From: Mahsa Pourebrahimi [REDACTED]
Sent: 15 December 2017 10:39
To: Michael Eastham
Cc: [REDACTED]
Subject: RE: BN/28/17/RES - The former Lillies Caravan Park, Barnham
Importance: High

- Landscaping drawing 11E-sheet 1 & 2 demonstrating the position of informal play area
- Drawing No. 17748-5-SK003, Section illustrating the cross-section of the basin in relation to the apartment block.

- I note that the proposer has suggested '**Attenuation basin shape revised and relocated to south western corner**' please can you request a copy of cross section through this area so that the basin shape in relation to the repositioned apartment block can be viewed as proposed build?
- Please can they also confirm where the play offer is to be sited in relation to the open space on the site?

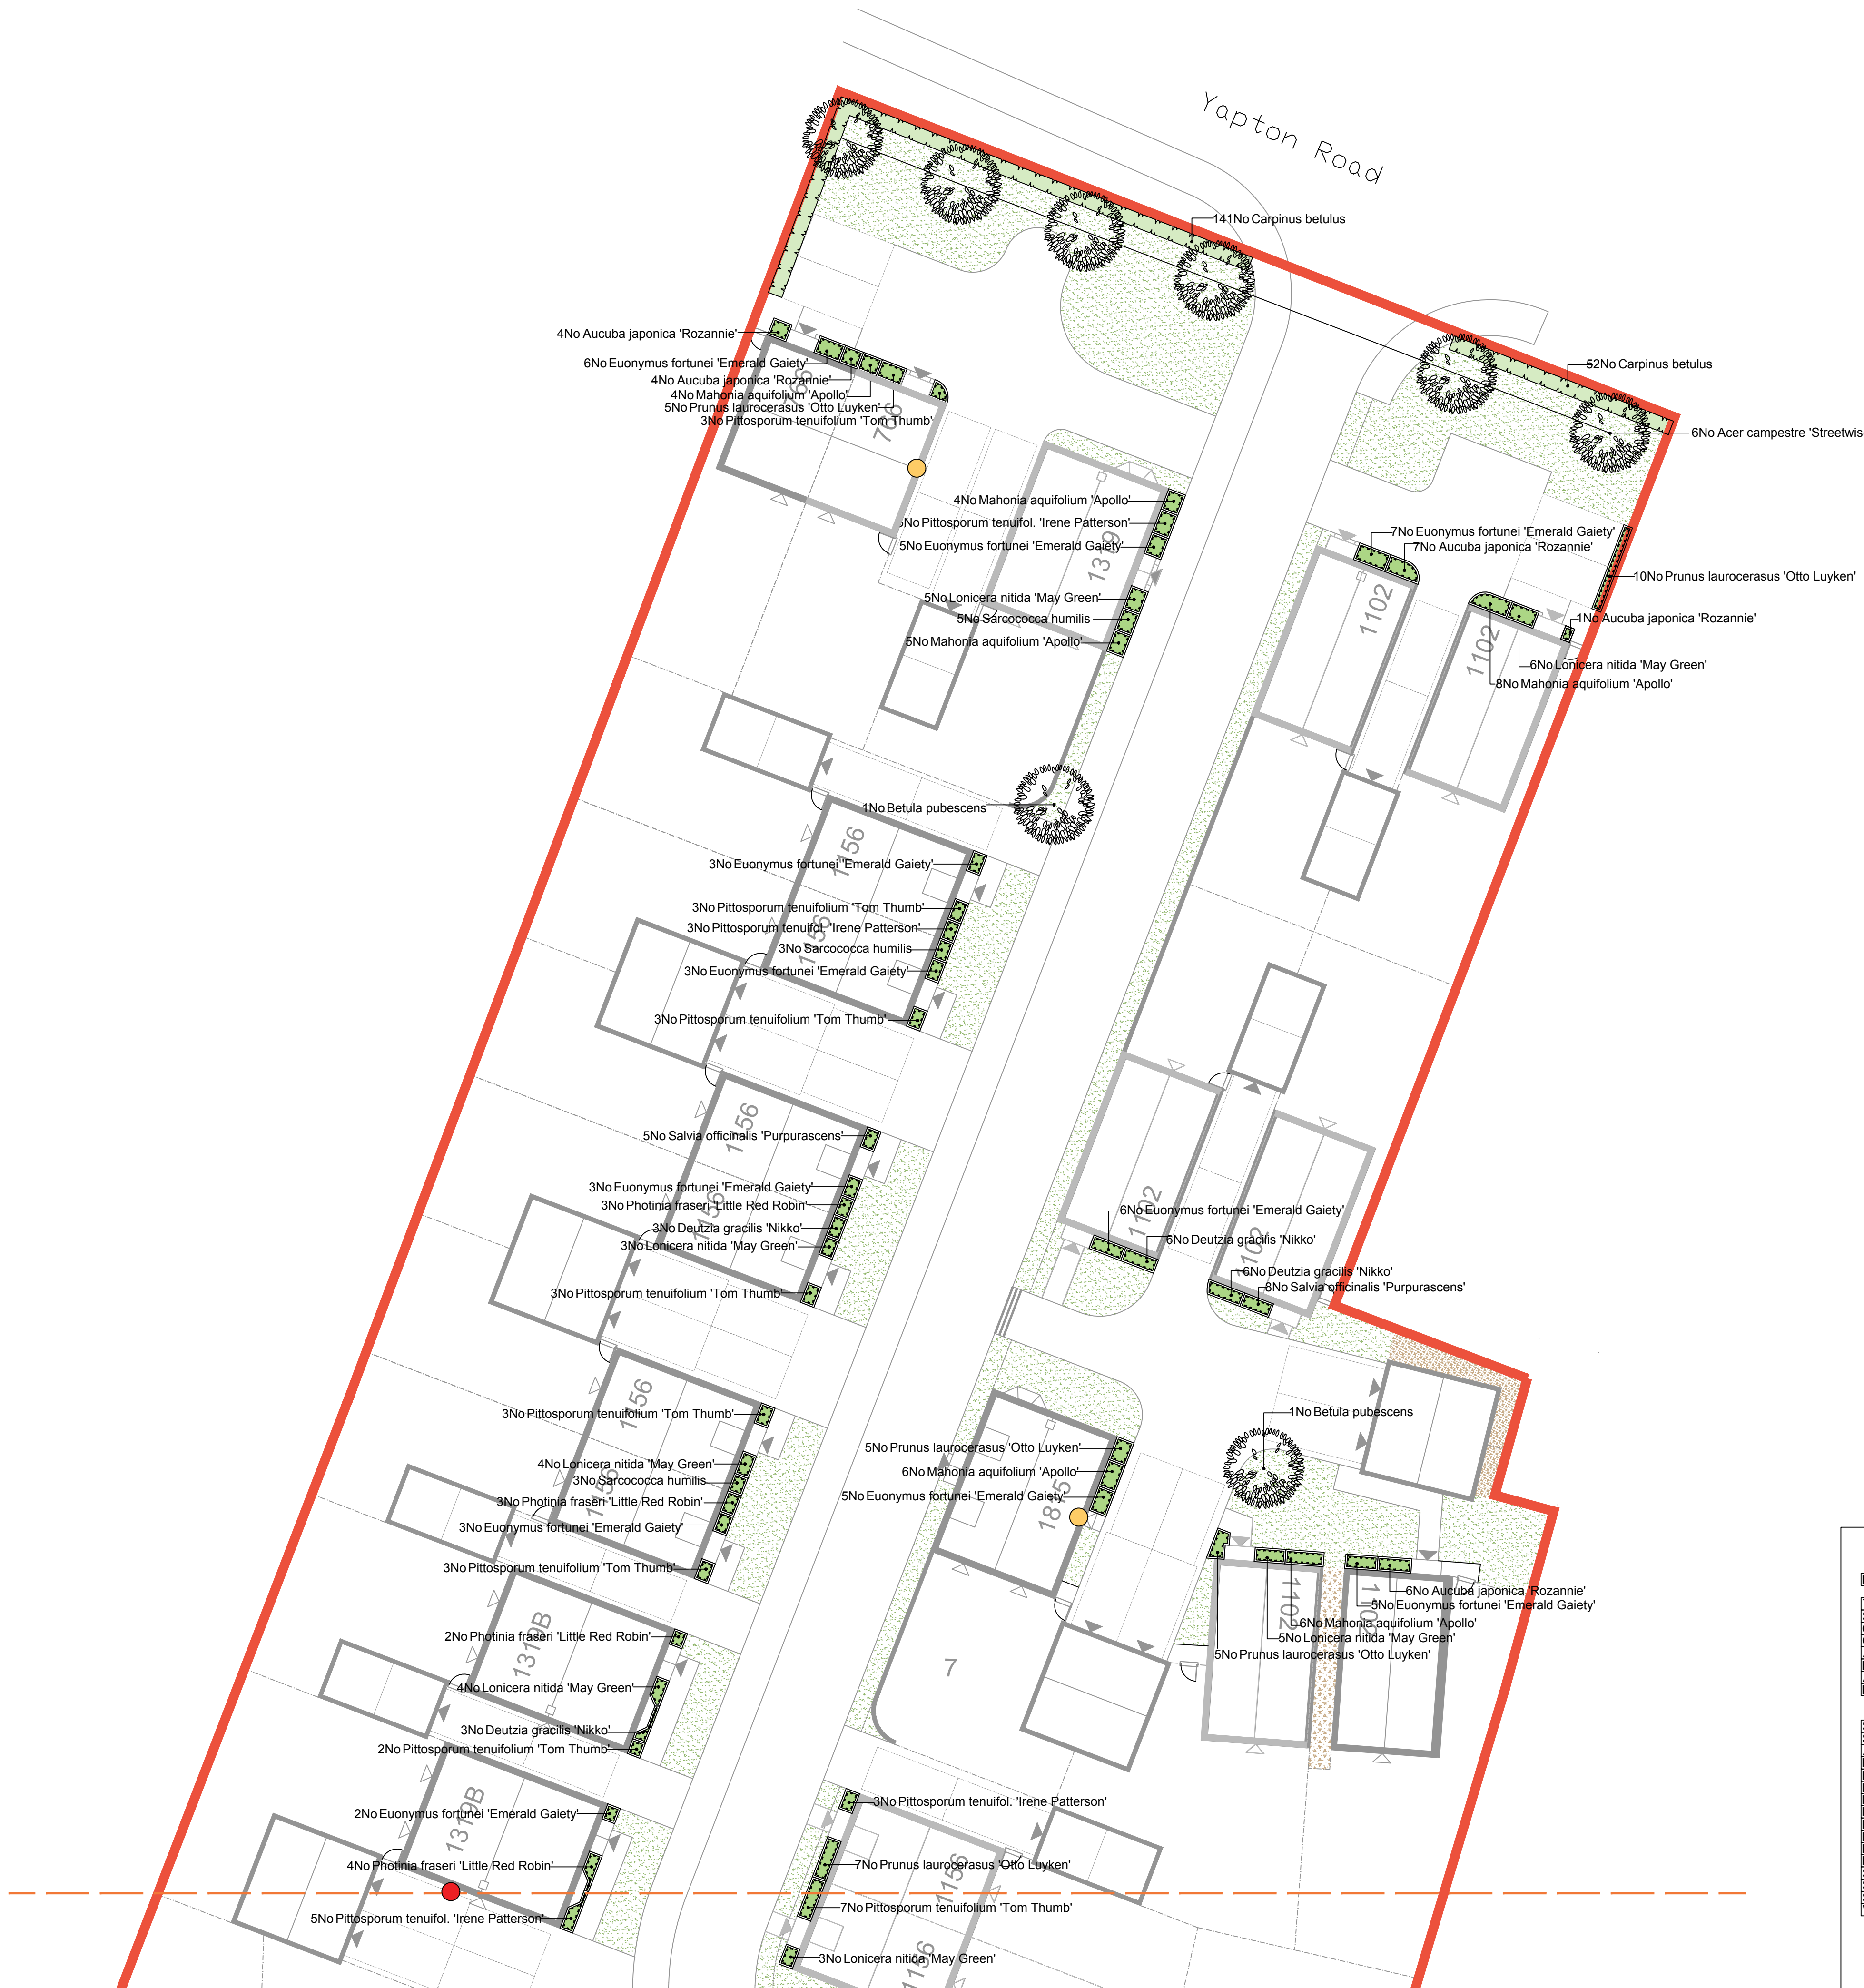
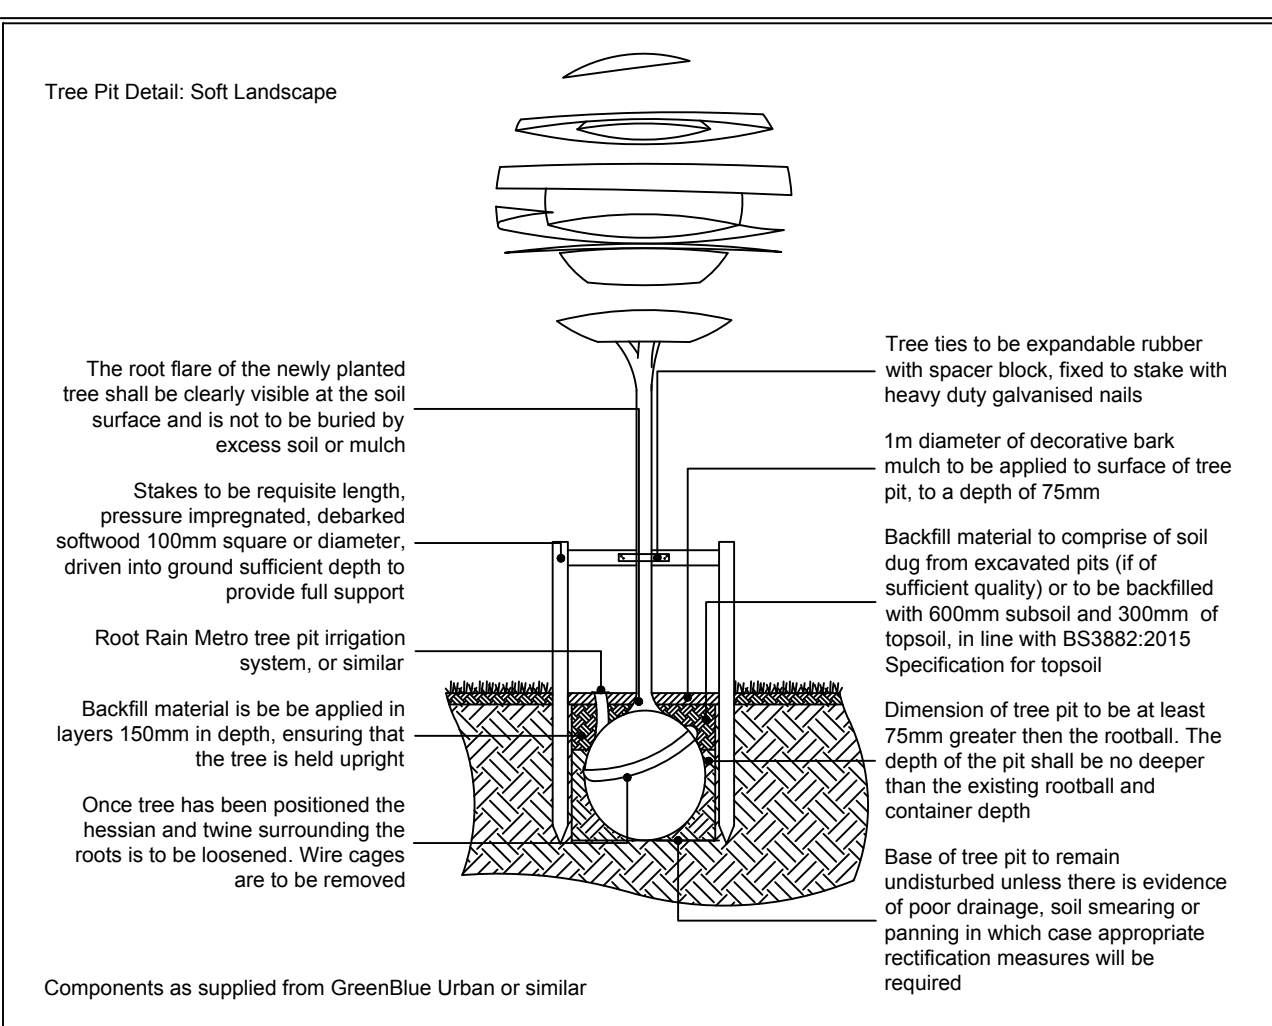
Please see the email from Sue Howell, below requesting a cross section through the south western corner of the site so that the basin shape in relation to the repositioned apartment block can be viewed as proposed build; and confirmation of where the play offer is to be sited in relation to the open space on the site.
